From: Anita Gardner
Sent: 26 September 2013 10:45
To: 'Jason Hales'
Subject: RE: Planning Consultation on: LU/241/13/L

APPLICATION NO: LU/241/13/L

Site Address: Toddington House Toddington Lane Littlehampton BN17 6JX

Description of Works: Application for Listed Building Consent for the demolition of single storey pantry to north elevation and erection of kitchen extension.

A NEW KITCHEN EXTENSION AT
 TOSINGTON HOUSE, LITTLEHAMPTON
 FOR MR + MRS WARON
 PROPOSED SITE PLAN
 PRM4, N° 740 / PO2A • SCALE
 1:200 AT A3.

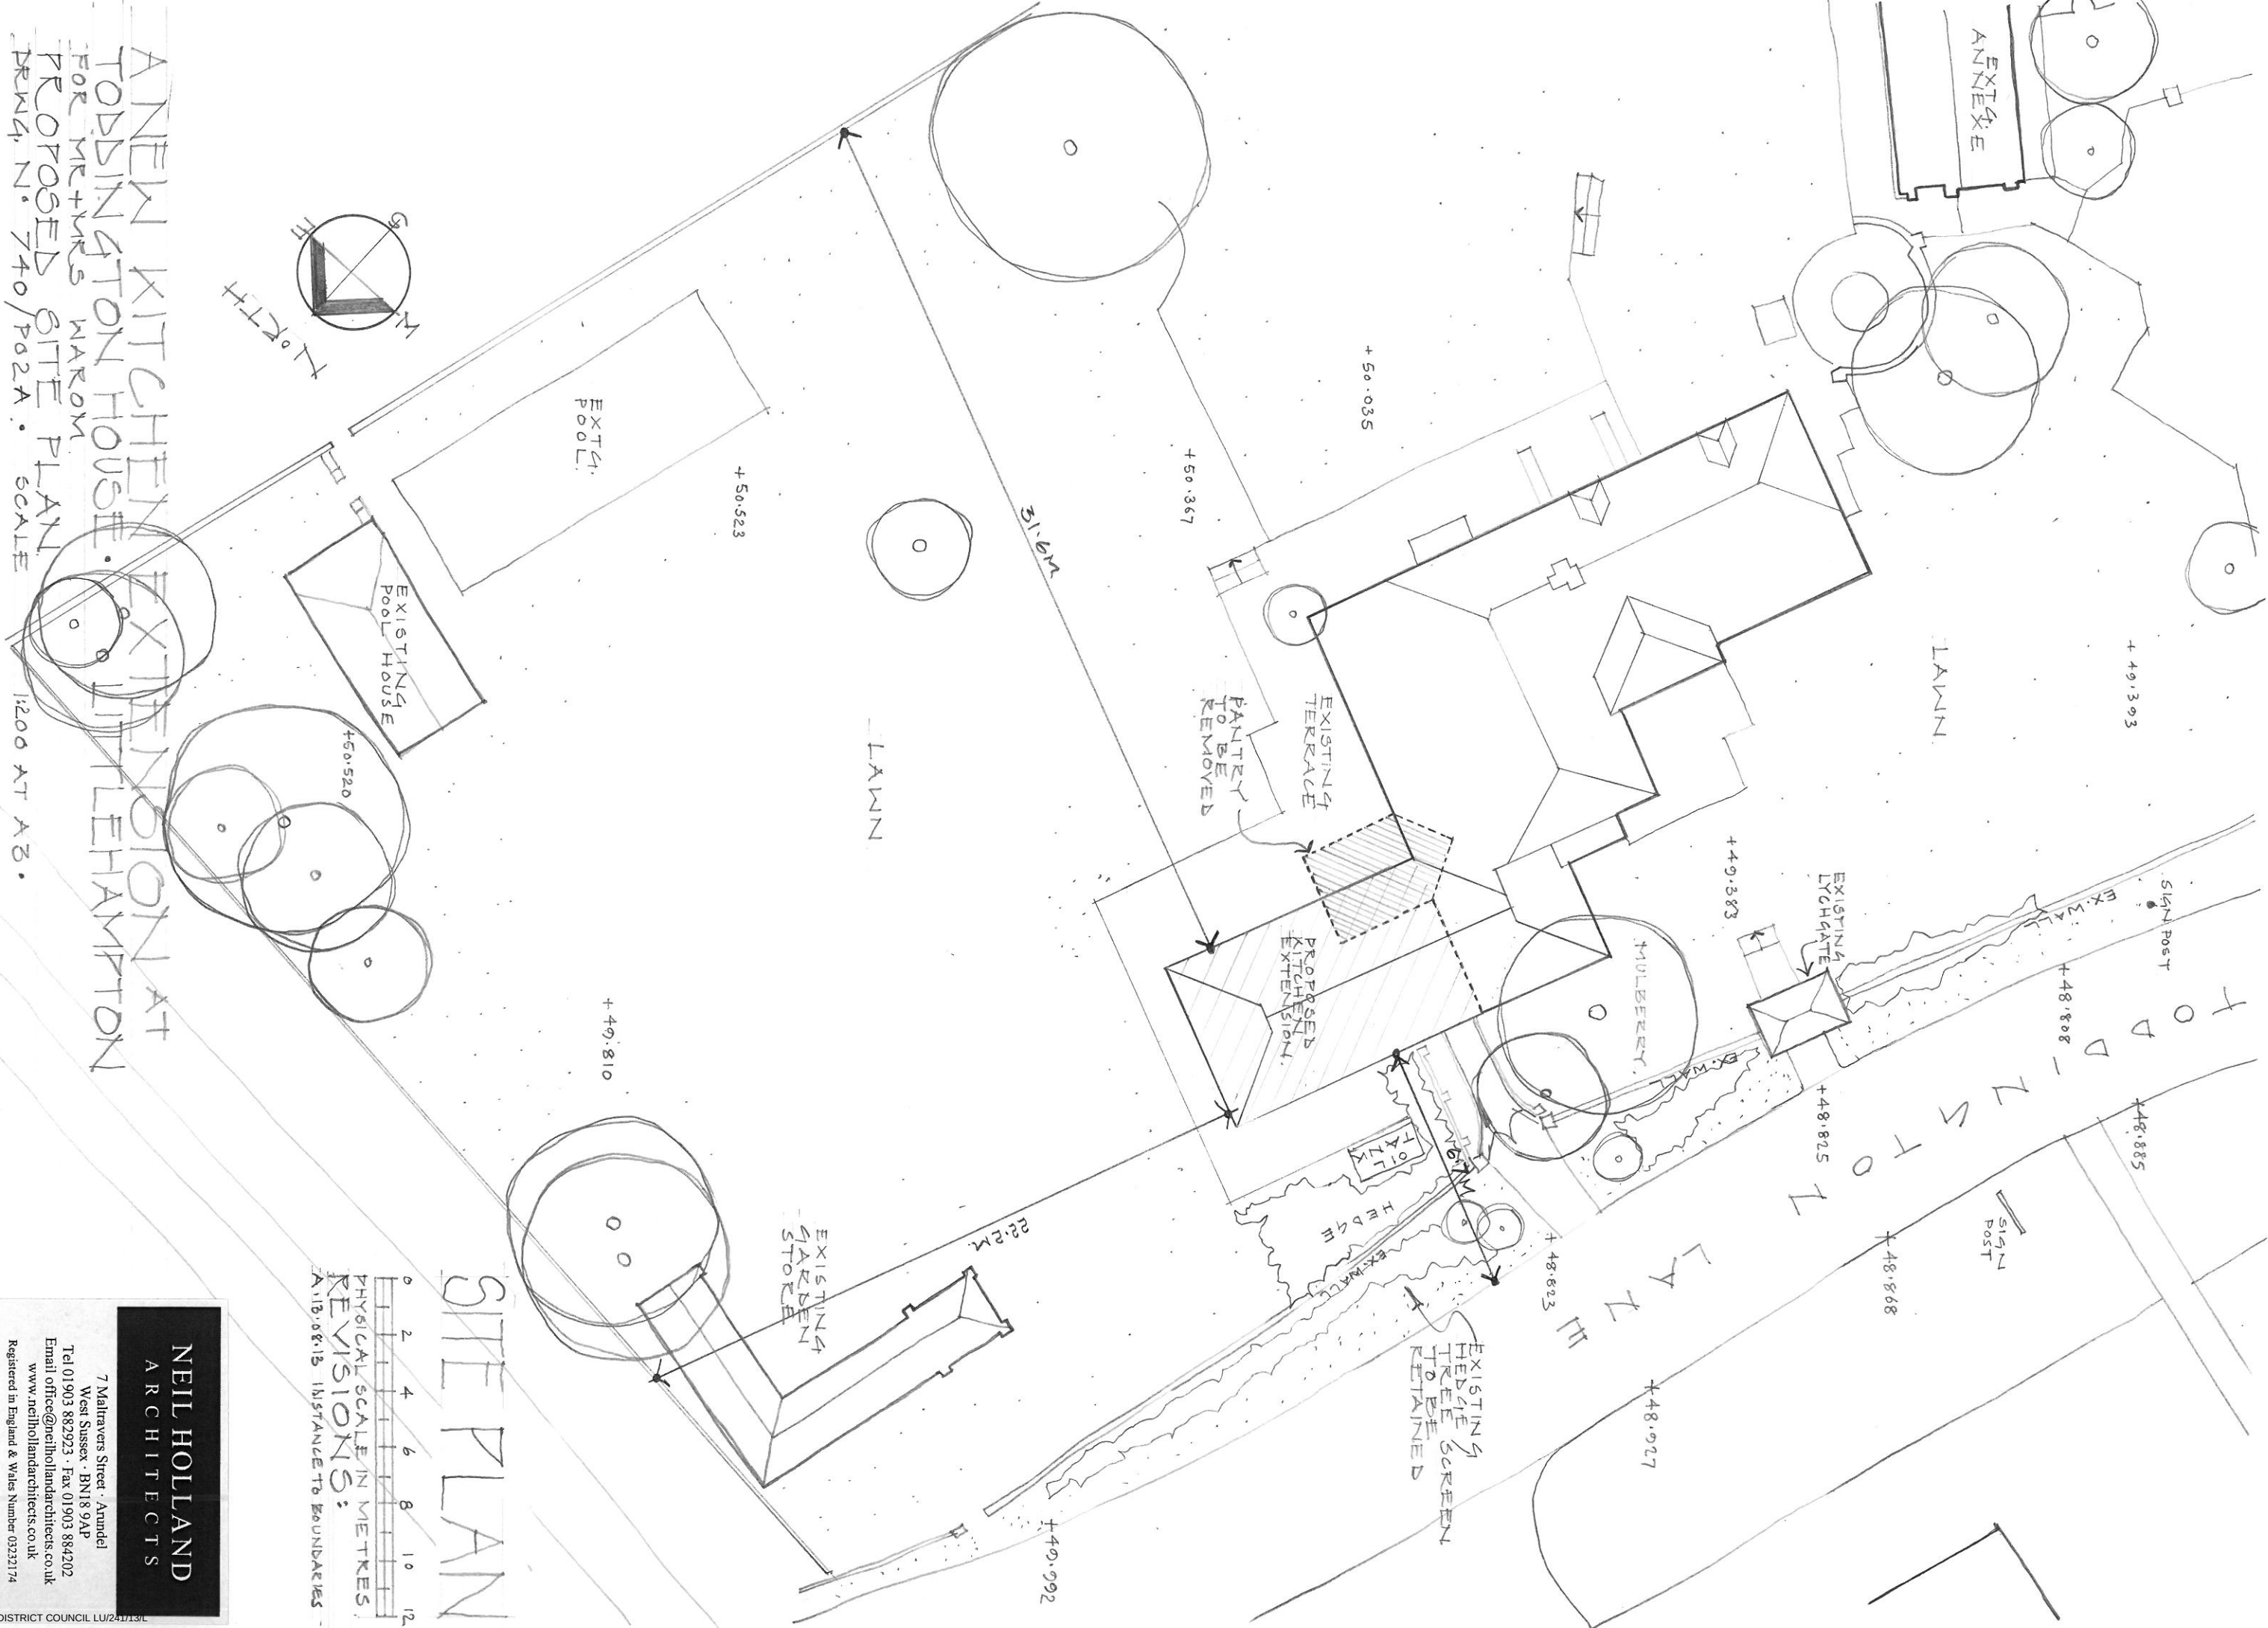
I discussed your proposal further with Dr Wightman yesterday. It is not considered that adequate justification for the size of extension proposed exists and therefore the applications will be recommended for refusal.

Ian Wightman visits the Council offices on a Wednesday, so he will not be here until next week. I will forward your comments to him, but he will not be in a position to provide a response until the middle of next week. A reduction in the length of the extension in addition to justification is being sought so it is likely your client will need to consider this possibility further.

Accordingly, without prejudice, I would welcome receipt of amended plans reducing the length of the extension by approx. 2.5 metres. It would also be useful if the extract of the proposed ground floor plan could indicate the proposed uses of the ex, dining room, kitchen and library.

Reading through his comments we indeed would like the opportunity to substantiate the scale of the extension in terms of the accommodation in respect to the proposed utility.

The need for a proper utility room is largely borne out of the fact that the client is losing an existing, much used large larder and kitchen equipment room store. The space for this can again be hidden away in its own space if housed in the proposed utility room.

During the design process we did look into putting the new utility room in the existing house – the library and existing kitchen, but these two spaces are too good and important to the existing house design complexity to become the utility for the following reasons:-

The library has rather wonderful panelled walls with bespoke bookcases and complex ceiling structure. Books are a very important element of the home and this room is a wonderful feature of the house. This is highly valued and will continue to be used as the library and music room. This makes the library an unsuitable option.

The existing kitchen space is to become the back hall and is the only thorough-fare through the main house to the new kitchen extension. Making this space into a Utility Room would be an unfeasible and impractically designed feature and would compromise the current, composite design features of the house and therefore would be unacceptable; the client understandably did not wish to fill it with utility units.

Rooms such as the second bedroom are already being used as other rooms for ironing etc and combined with the above reasons, we believed this substantiated the need to position the new utility in the new extension out of the existing house.
